CITY OF ALBUQUERQUE

July 21, 2017

RE: **Blakes Lotaburger**
1640 Gibson Blvd SE
Revised Grading and Drainage Plan
Engineer's Stamp Date 7/20/17 & 7/12/17 (File: M15D012A)

DRAINAGE MANAGEMENT PLAN

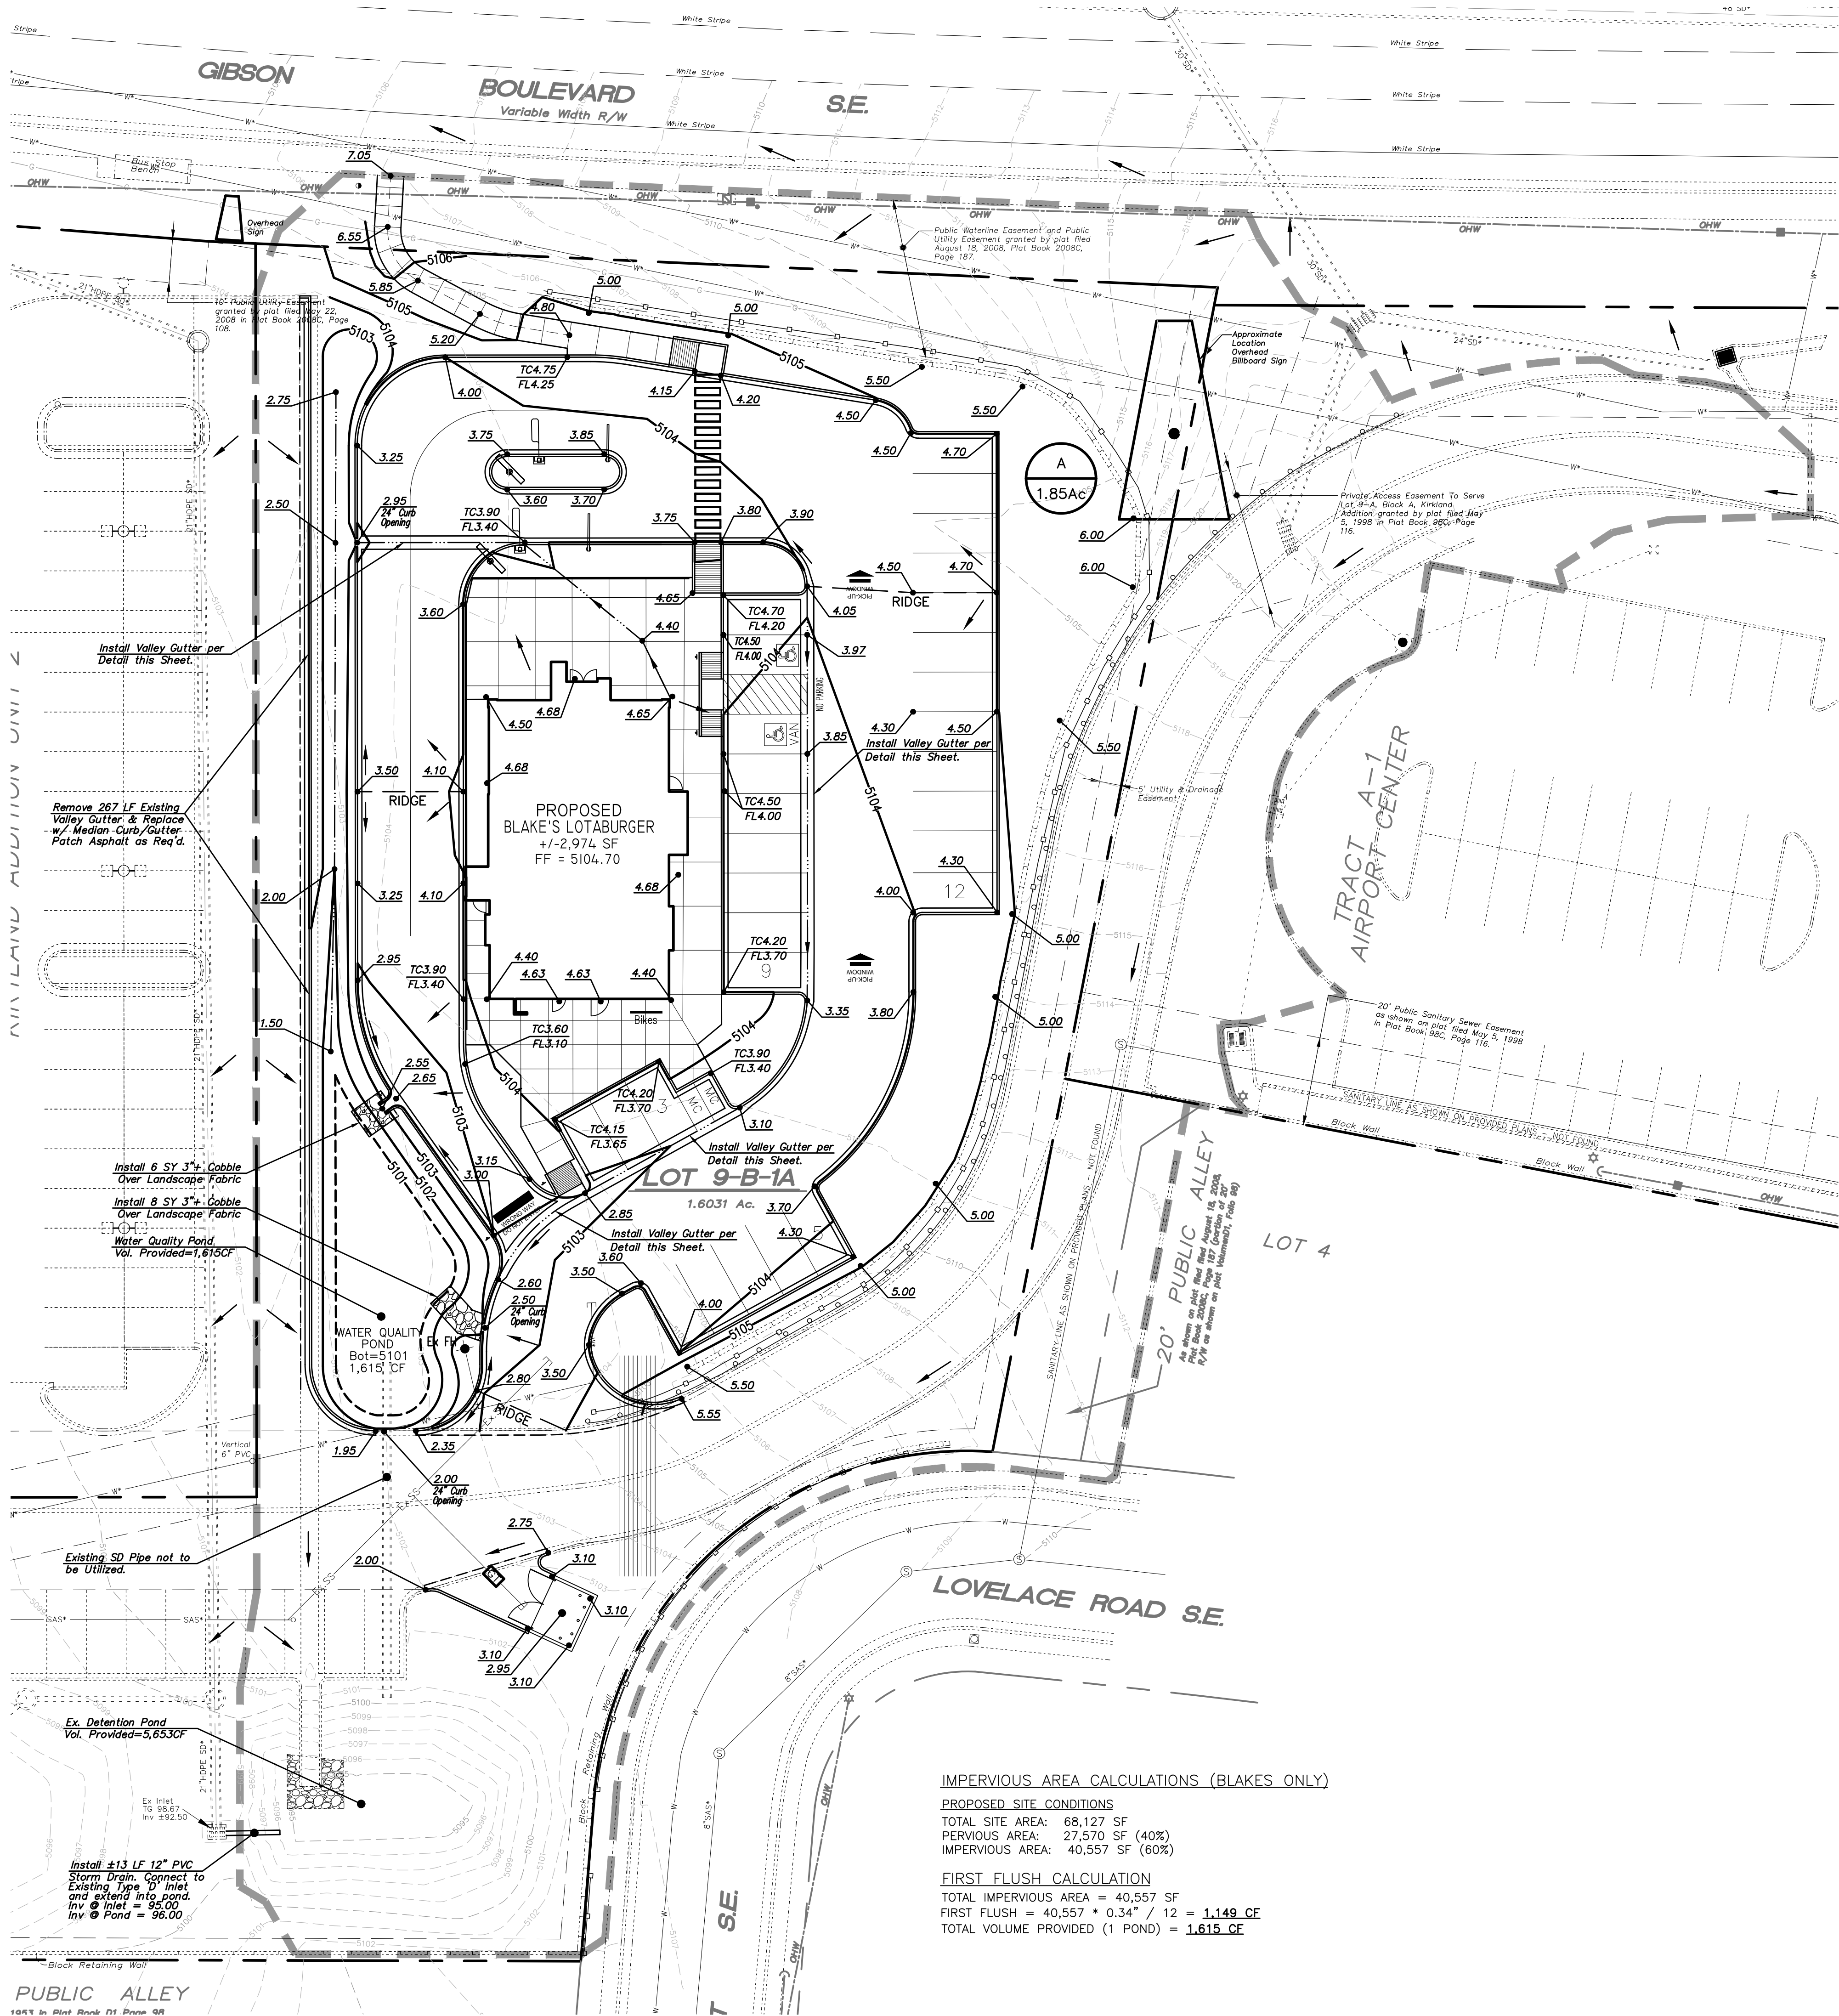
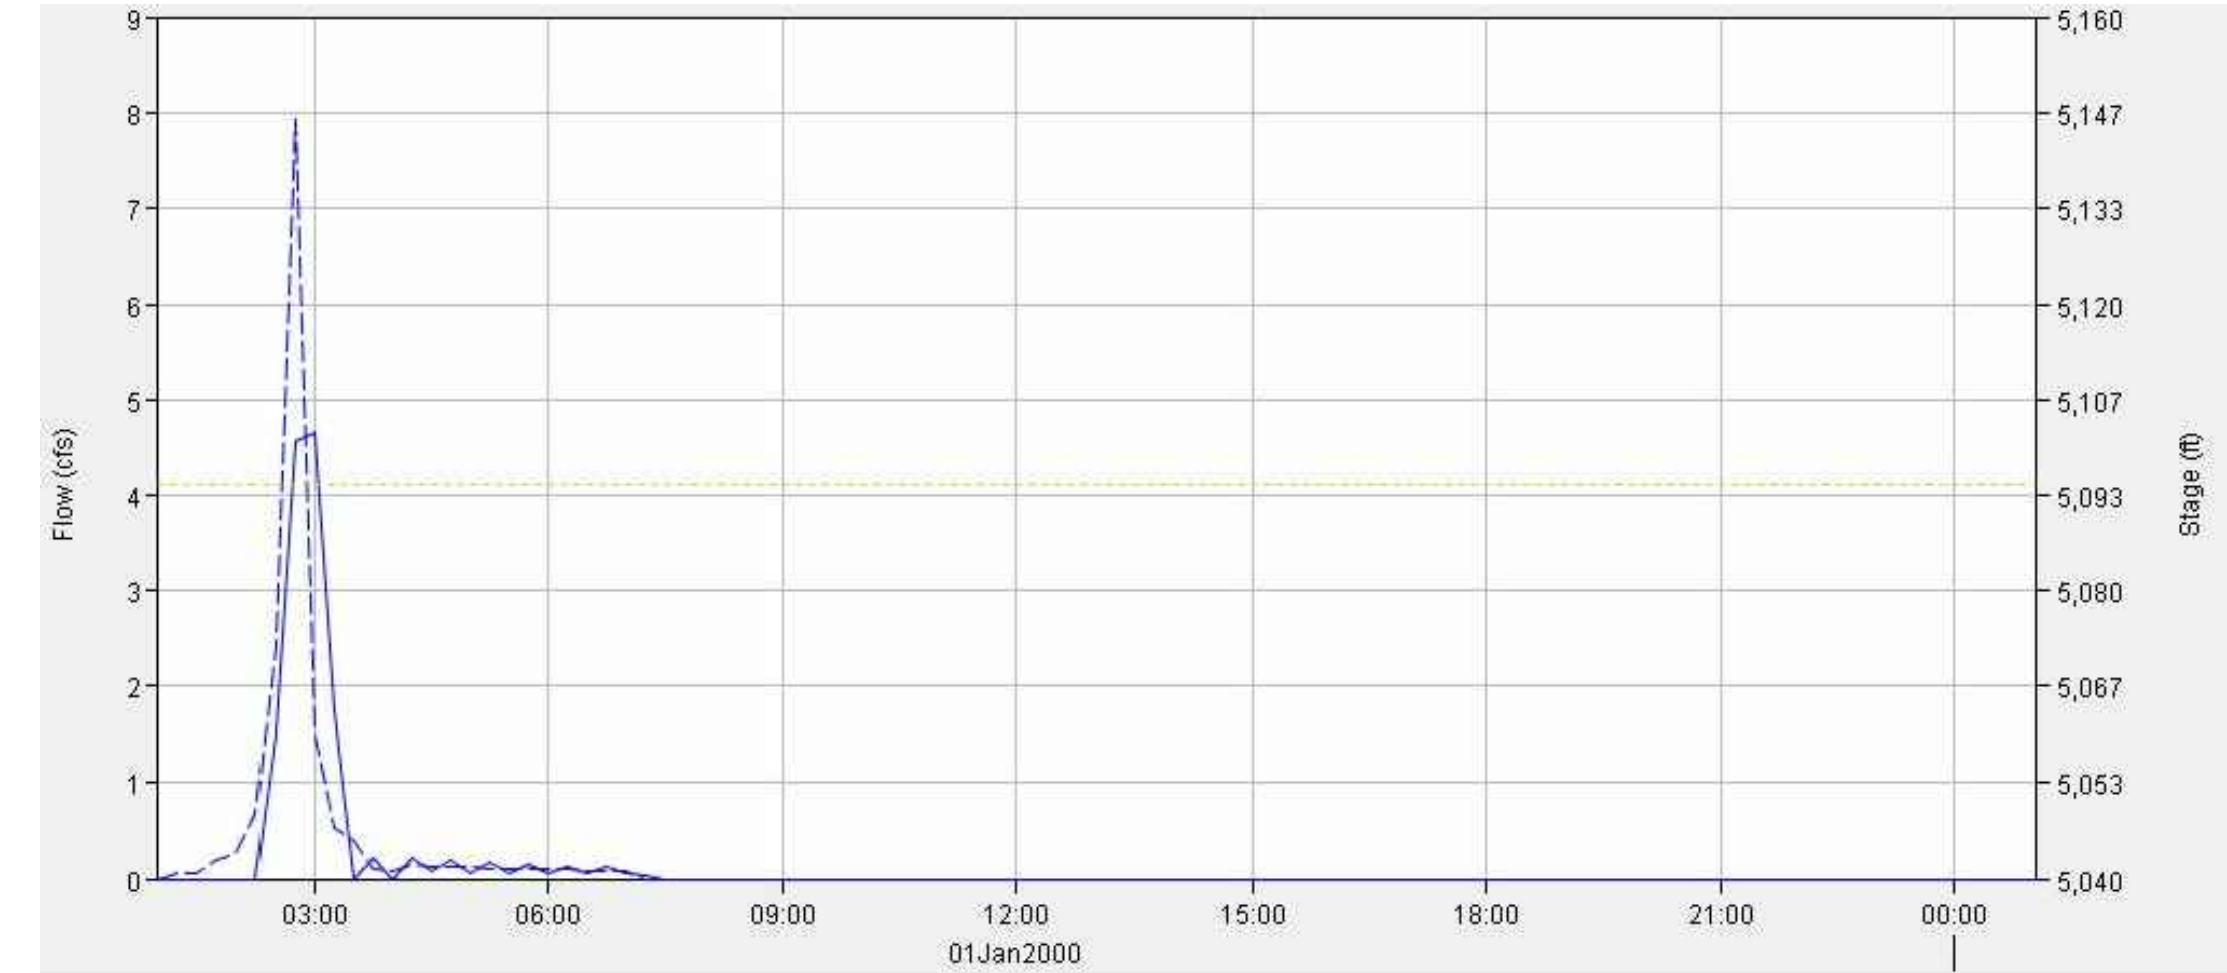
1. Provide additional spot elevations along the west edge of the new median curb and gutter. This side of the island will need to drain north to south.
2. Correct the last sentence of "Proposed Hydrologic Conditions" to reflect the new drainage scheme.

The enlarged south pond with additional dead storage is an acceptable modification, but will need to be surveyed, as-built, and the constructed volume certified as part of the Engineer's Drainage Certification.
